From: [REDACTED]
Sent: 30 July 2008 11:41
To: Keith Wheway
Subject: Re: BR/60/08 Mc and Stone Hawthorn Road Bognor

Sorry for the delay on this. In respects of conditions 14, 17 and 23, I would offer the following comments,

TYPICAL SECTION THRU ADOPTABLE CROSSOVER

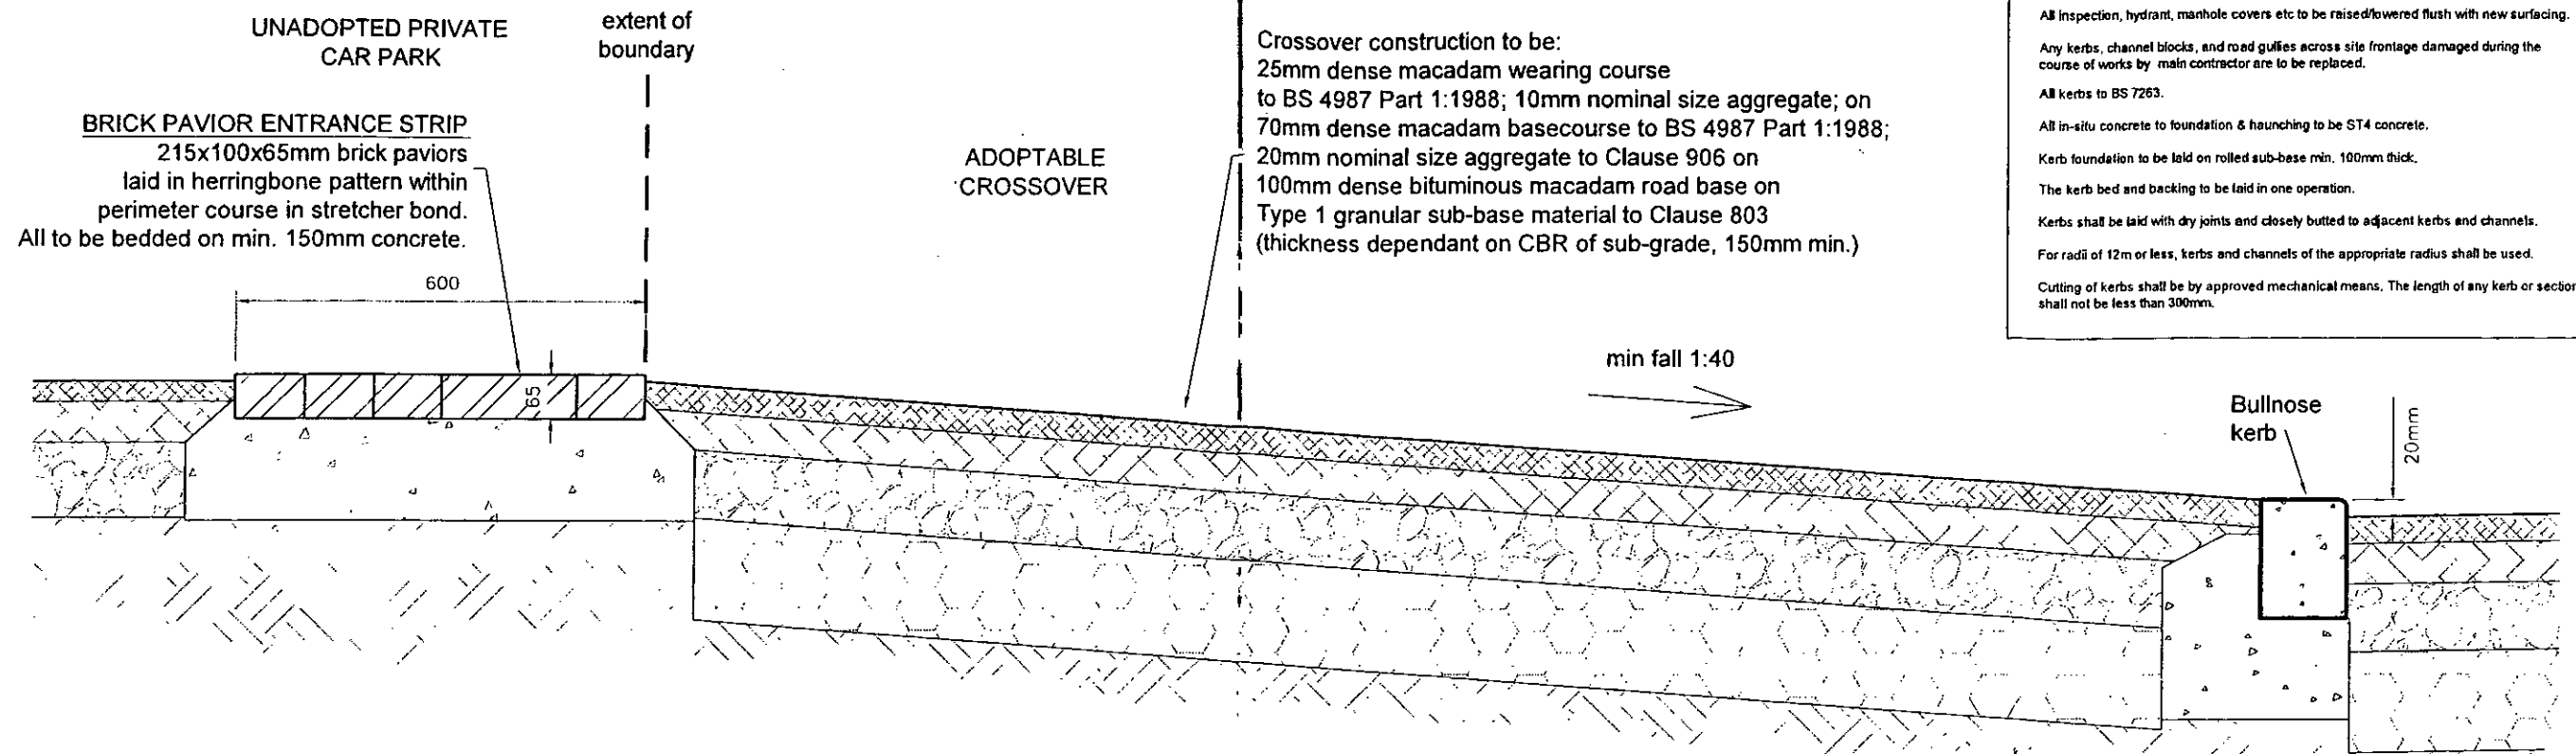
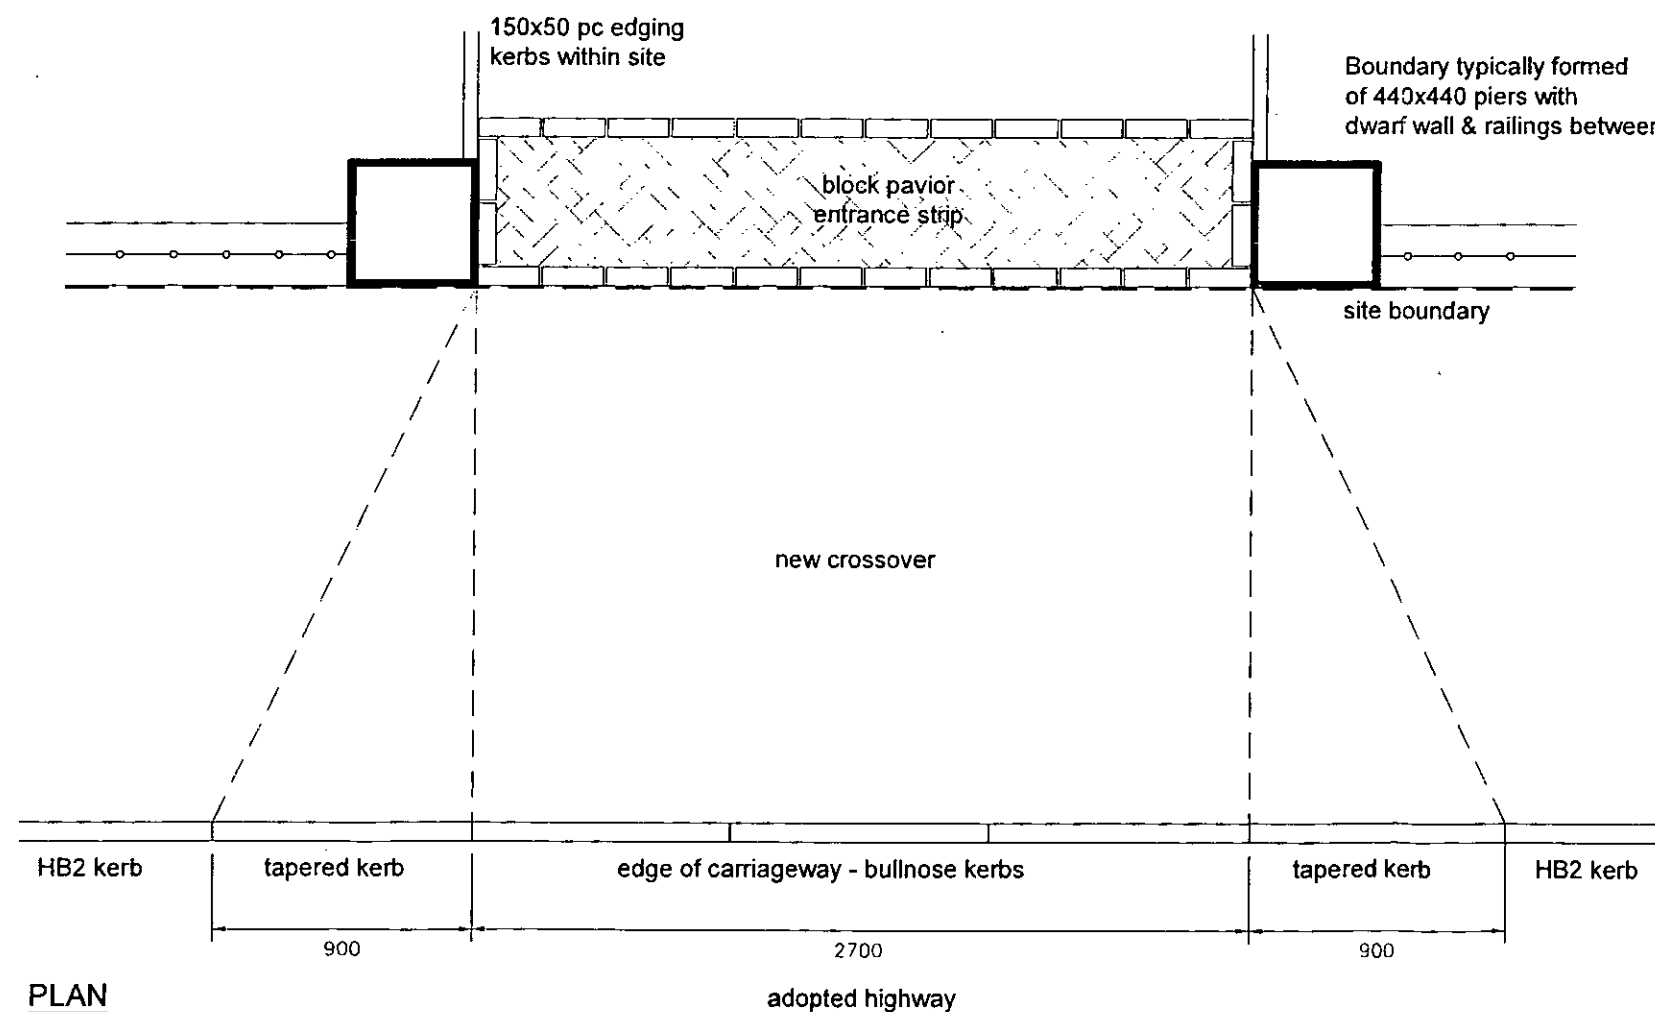
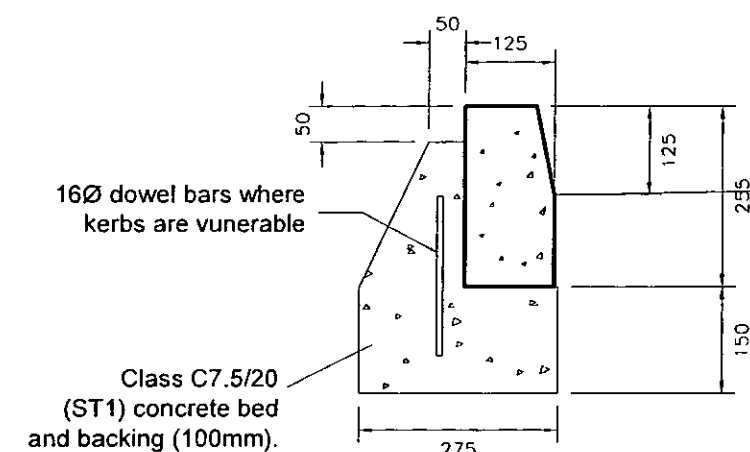
Drawing no. 10/1441/006 shows the installation of an acco drain at the boundary of the private land and the public highway. This would be a satisfactory means of preventing surface water from draining onto the public highway. Whilst this condition would appear to relate to a number of other drainage related matters, from a highway perspective, this condition may be discharged.

Drawing no. 10/1441/006 shows the provision of visibility splays concurrent with the results of the speed survey as detailed within the report from Dr A Burns. In any case it is evident that visibility is achievable to the appropriate standard for a 30mph speed limit as detailed within Manual For Streets. The condition requires kerb radii to be indicated at the access. However as a crossover is proposed, no kerb radii would be required. In principle, the provision of a crossover would be acceptable. Therefore, the details are considered acceptable and this condition may be discharged.
